DELEGATED HOUSEHOLDER DECISION

77235/APP/2022/1373 - Erection of a single storey rear extension and conversion of roofspace to habitable use to include a rear dormer with a Juliette balcony and conversion of roof from hip to gable end. - Refused 22-06-22

An assessment of the plans and a site inspection has revealed that the main alterations between the as-built single storey rear extension (subject of this retrospective application) and the previously approved single storey rear extension (application reference: 77235/APP/2022/2138) can be

Project Title 34A NORTHOLT AVENUE RUISLIP HA4 6ST		Drawing Title EXISTING FLOOR PLANS, ELEVATION	
ARCH/CLIENT	Drawn BC	Scale 1:50	Size A2
		Project No. 2207/195	Rev. C
		Drawing No. PE-02

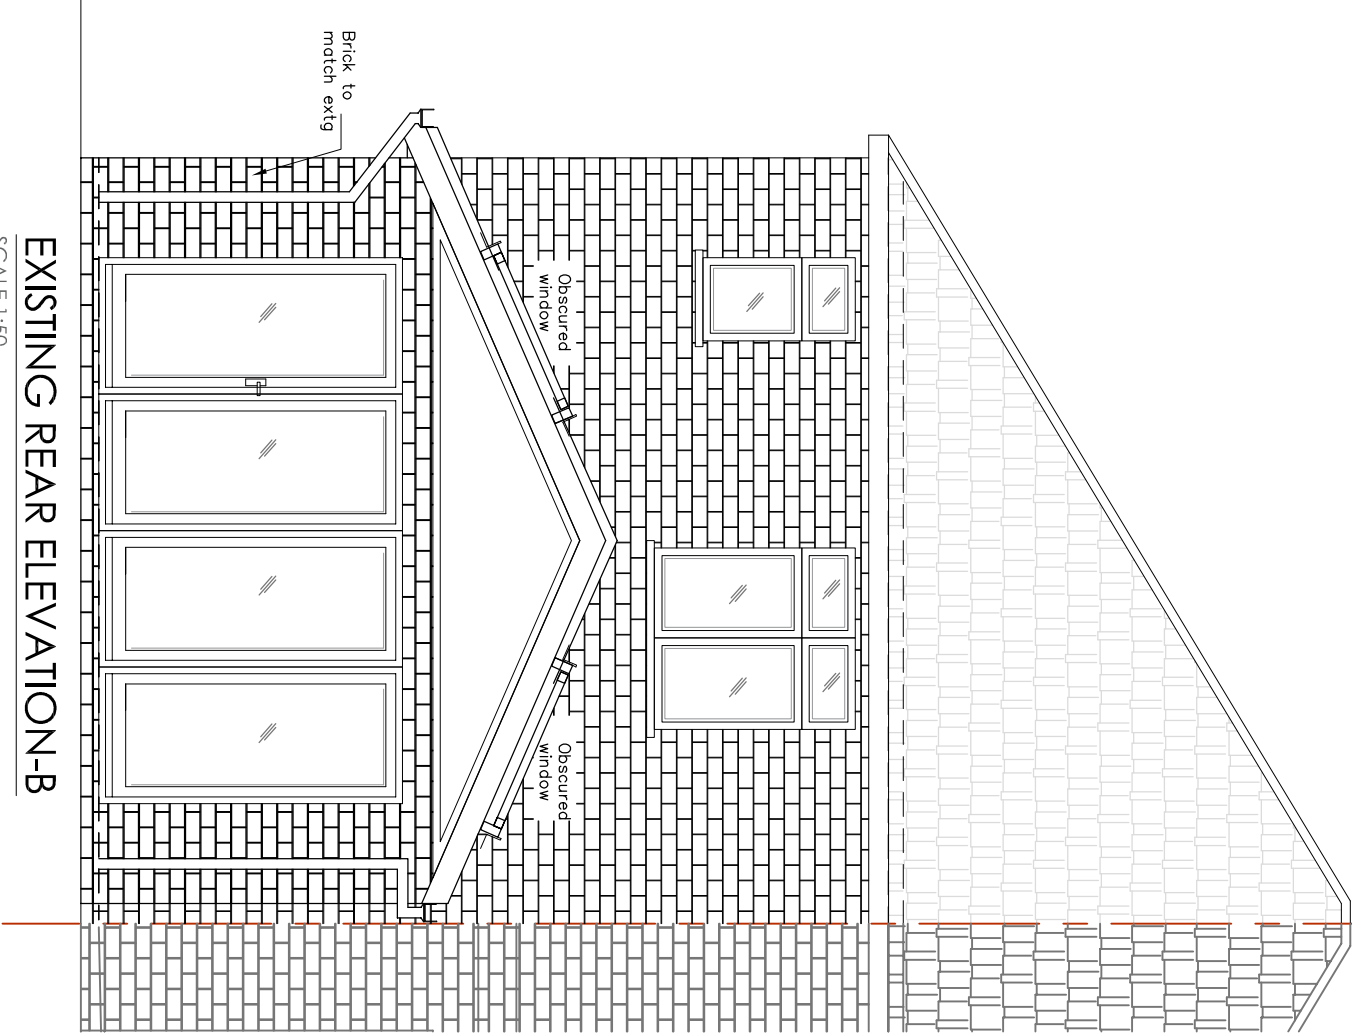
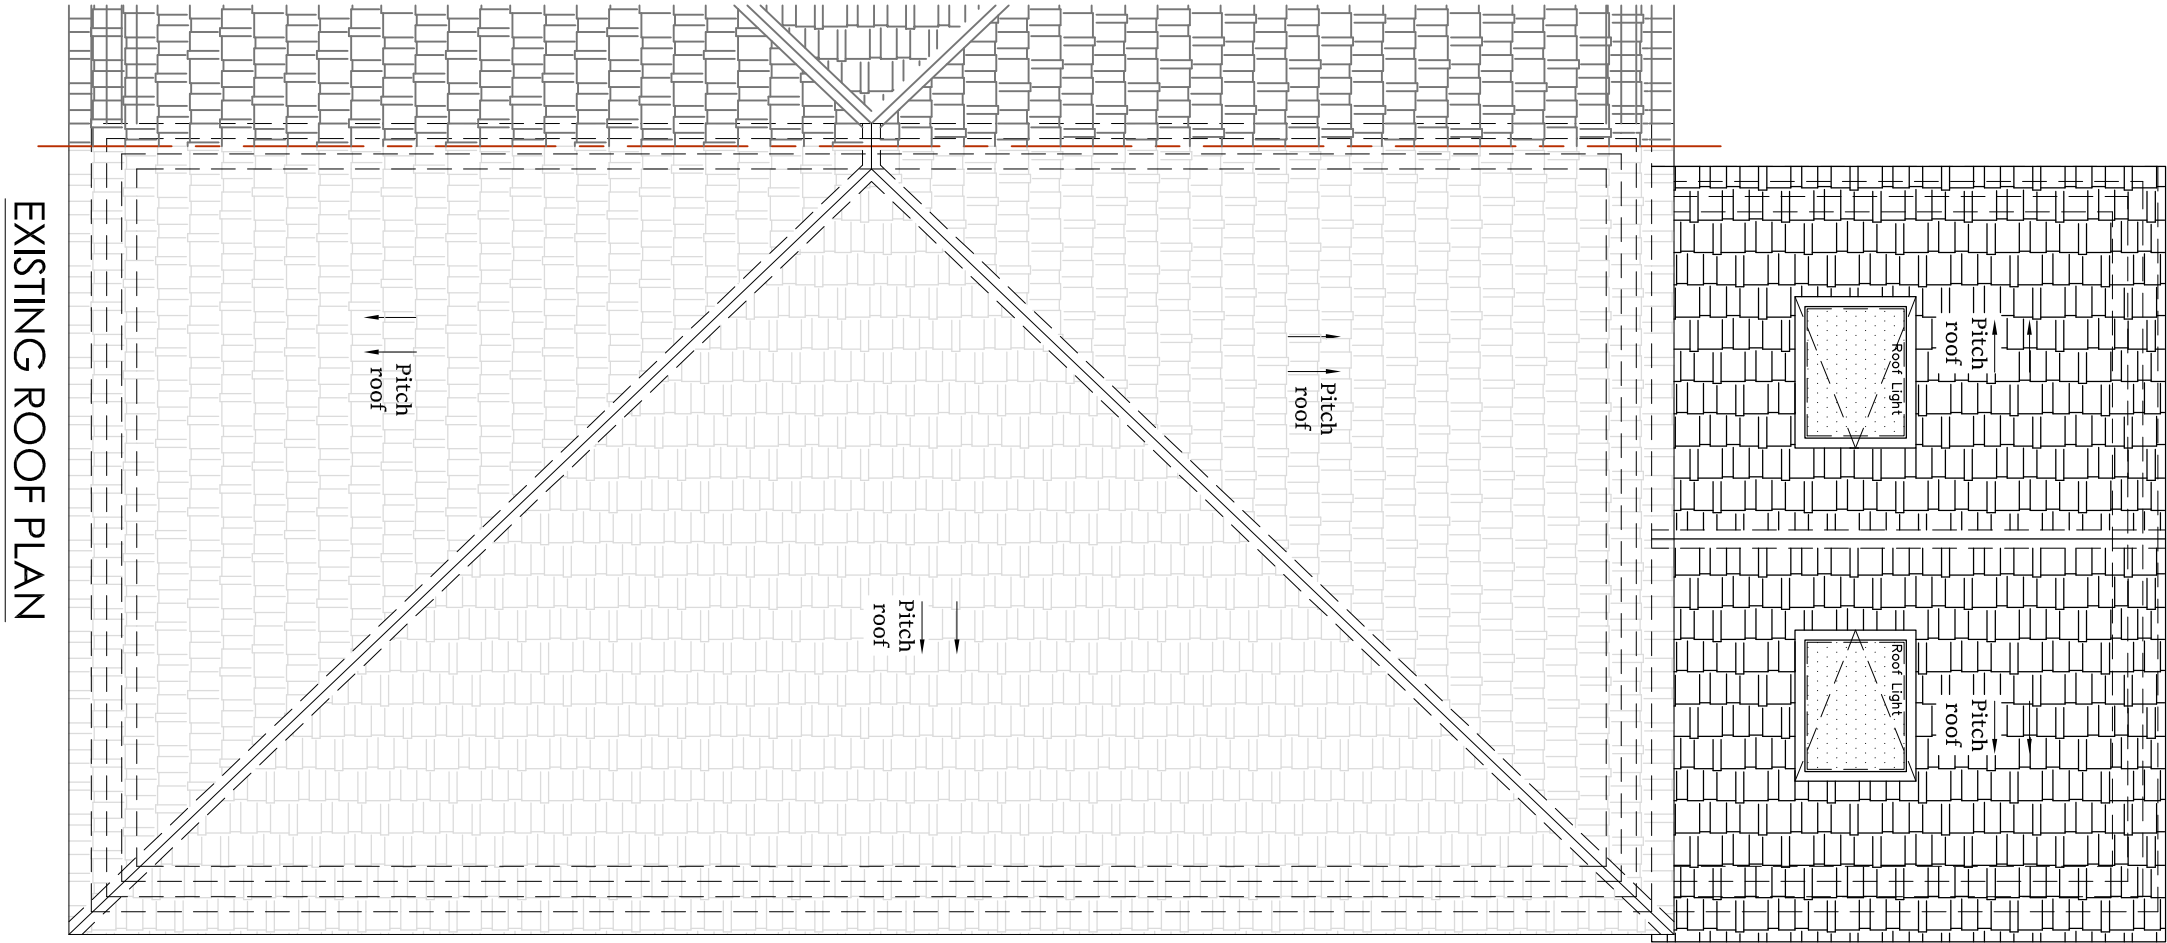
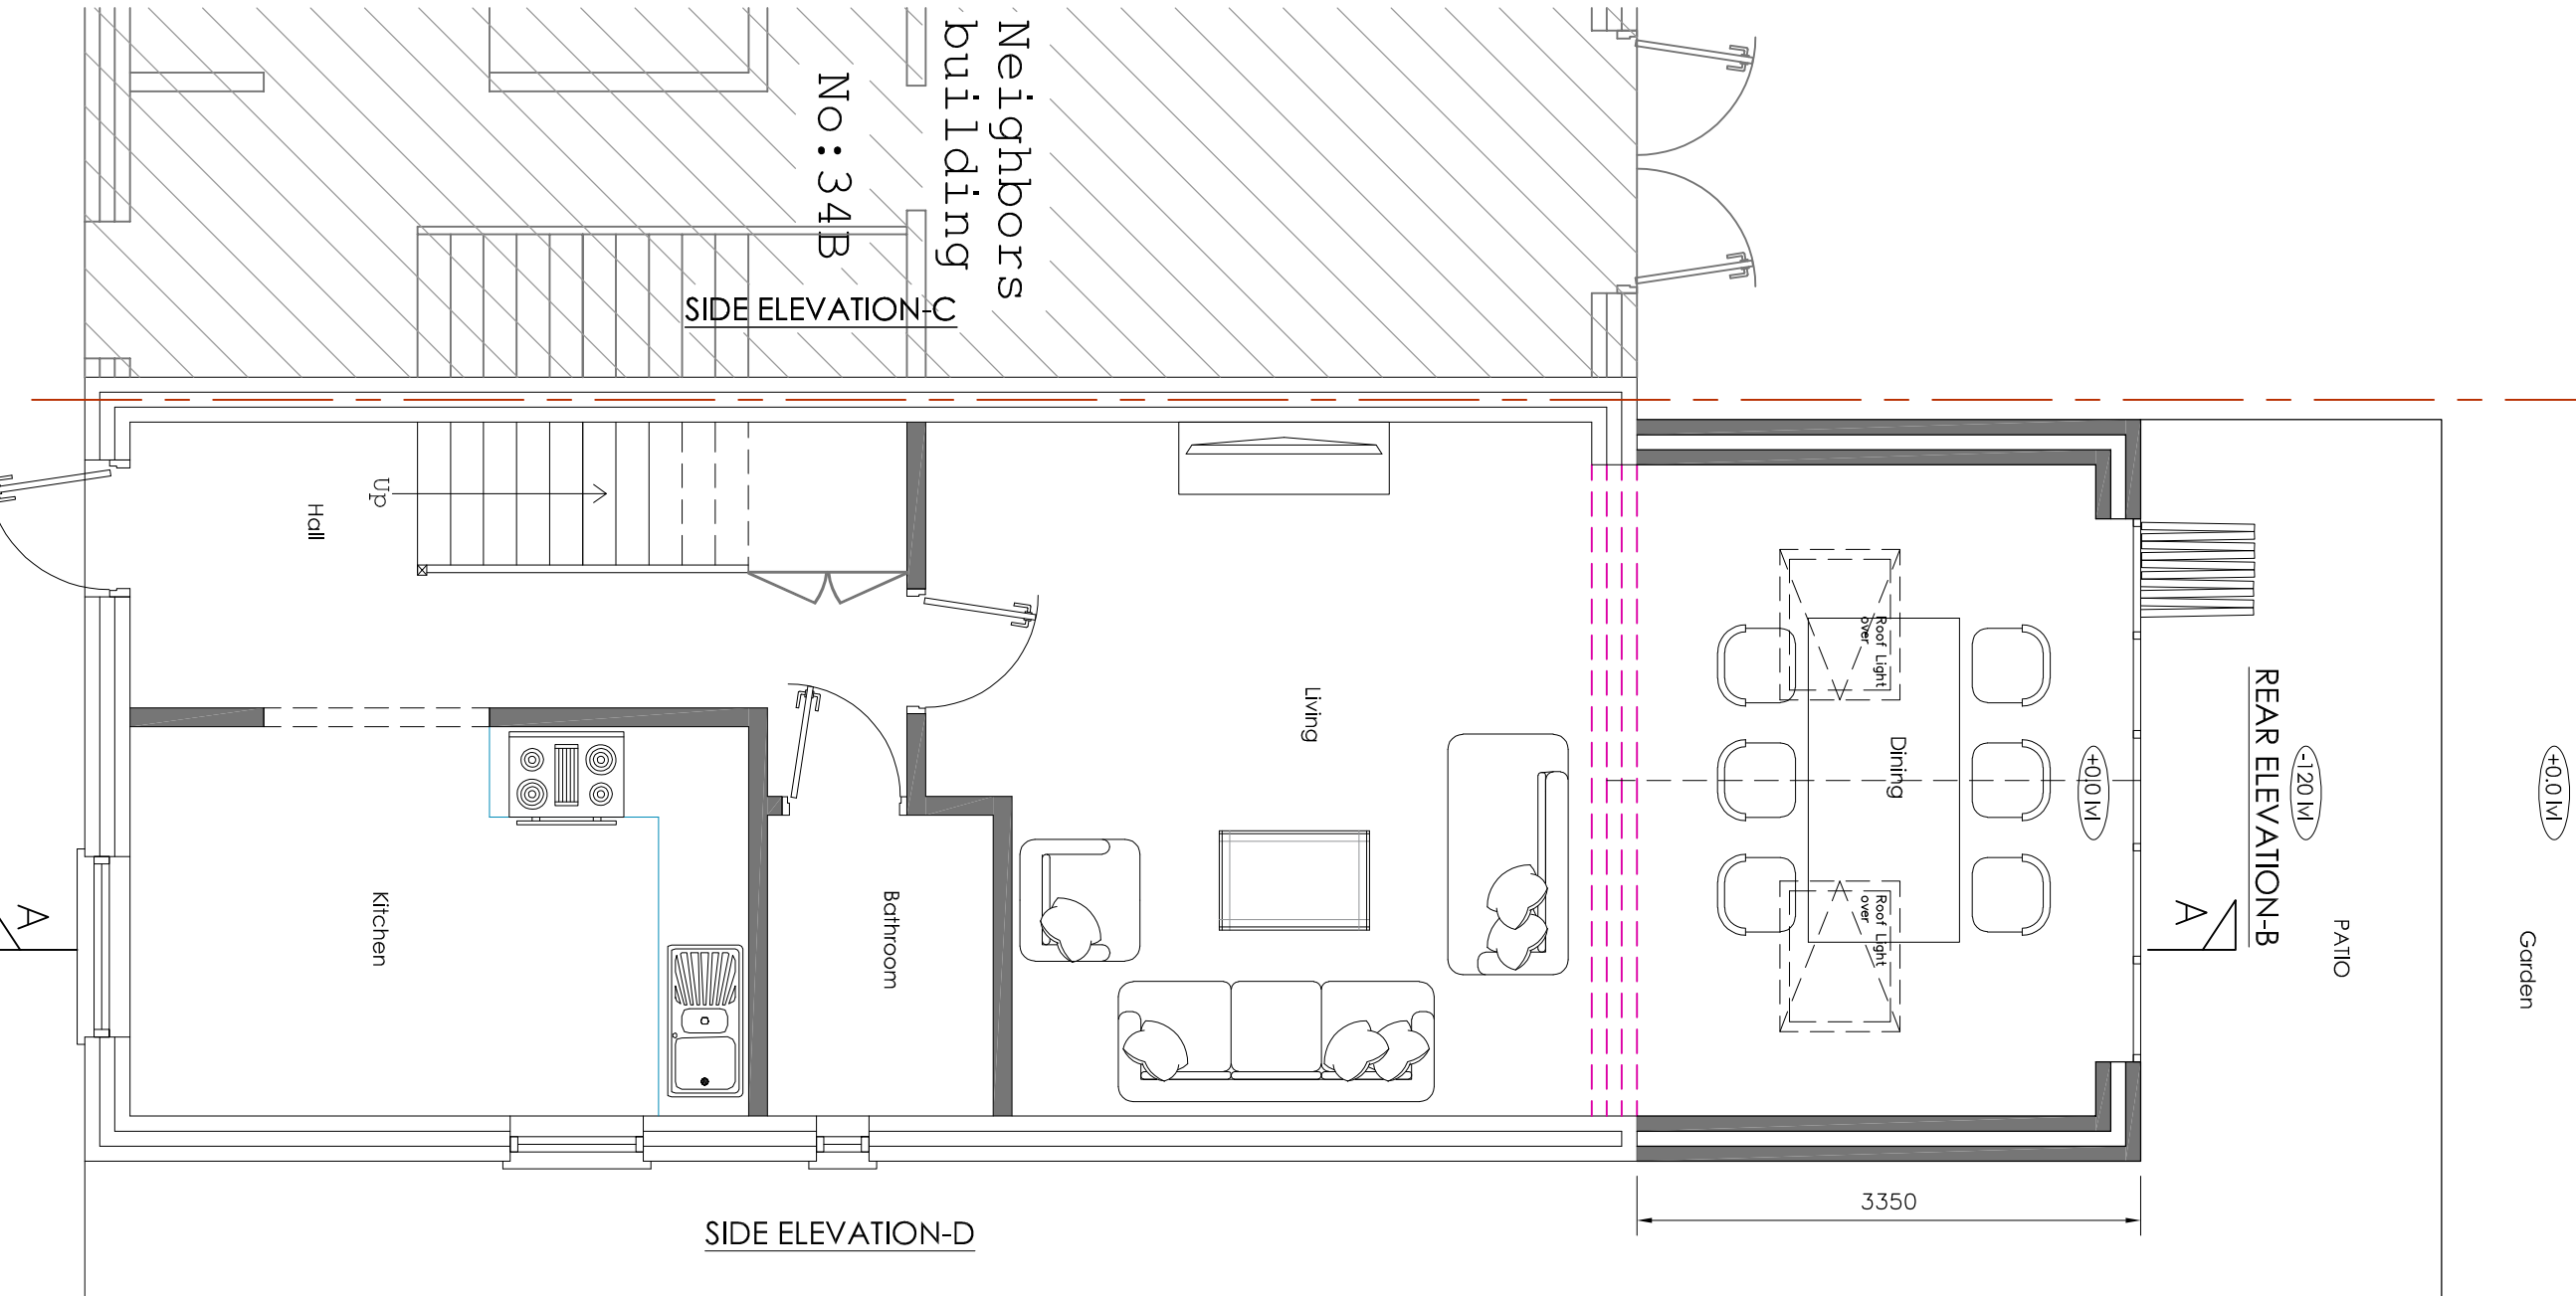
- Depth of the rear extension has increased from 3.3m to 3.35m;
- Eaves height has been increased from 2.25m to 2.4m;
- Maximum height of the pitched roof has increased from 3.15m to 3.54m and;
- Glazed panel below above bi-fold doors, replacing the approved brick work.

In terms of Policy DMHD 1, the proposed depth of the extension is policy compliant. The maximum height of the rear extension at 3.54m is marginally above the 3.4m threshold recommended in Policy DMHD 1, however it is noted that this is a marginal difference and the eaves height of the extension remains relatively low. The proposed glazed panel above the bi-fold doors is considered acceptable.

The proposed extension would extend 3.35m beyond the rear building line of the attached neighbouring property, 34B Northolt Avenue. The rooflights on the sides of the pitched roof are obscurely-glazed and would be 2.6m above the finished floor level. Given the modest depth of the proposed extension, the modest height of the proposed dual-pitched roof ridge and eaves and the obscure-glazed side rooflight, it is considered that the proposed development would not adversely harm the neighbouring amenity of 34B Northolt Avenue in terms of loss of light, outlook or privacy.

The existing rear building line of the application property is situated 1.34m beyond the rear building line of the neighbouring property 30D Northolt Avenue due to the staggered building lines. The proposed 3.35m deep extension, combined with the existing 1.34m projection beyond the neighbouring property, would result in the application property extending 4.69m beyond the neighbouring property. However, there is a separation distance of approximately 1.85m between the flank walls of Nos.30D & 34A Northolt Avenue. It is considered that this separation distance serves to mitigate any undue impacts from the development on the residential amenity of 30D Northolt Avenue. The proposed rooflight on the side of the pitched roof would be obscure-glazed and would be 2.6m above the finished floor level. Given the modest depth of the proposed extension, the modest height of the proposed dual-pitched roof ridge and eaves, the separation distance between the two properties, and the obscure-glazed side rooflight, it is considered that the proposed development would not adversely harm the residential amenity of 30D Northolt Avenue in terms of loss of light, outlook or privacy.

The development hereby permitted shall be retained and completed in accordance with the details shown on Drawing Nos. PE-02 Rev. C, PE-03 Rev. C & PE-04 Rev. C.
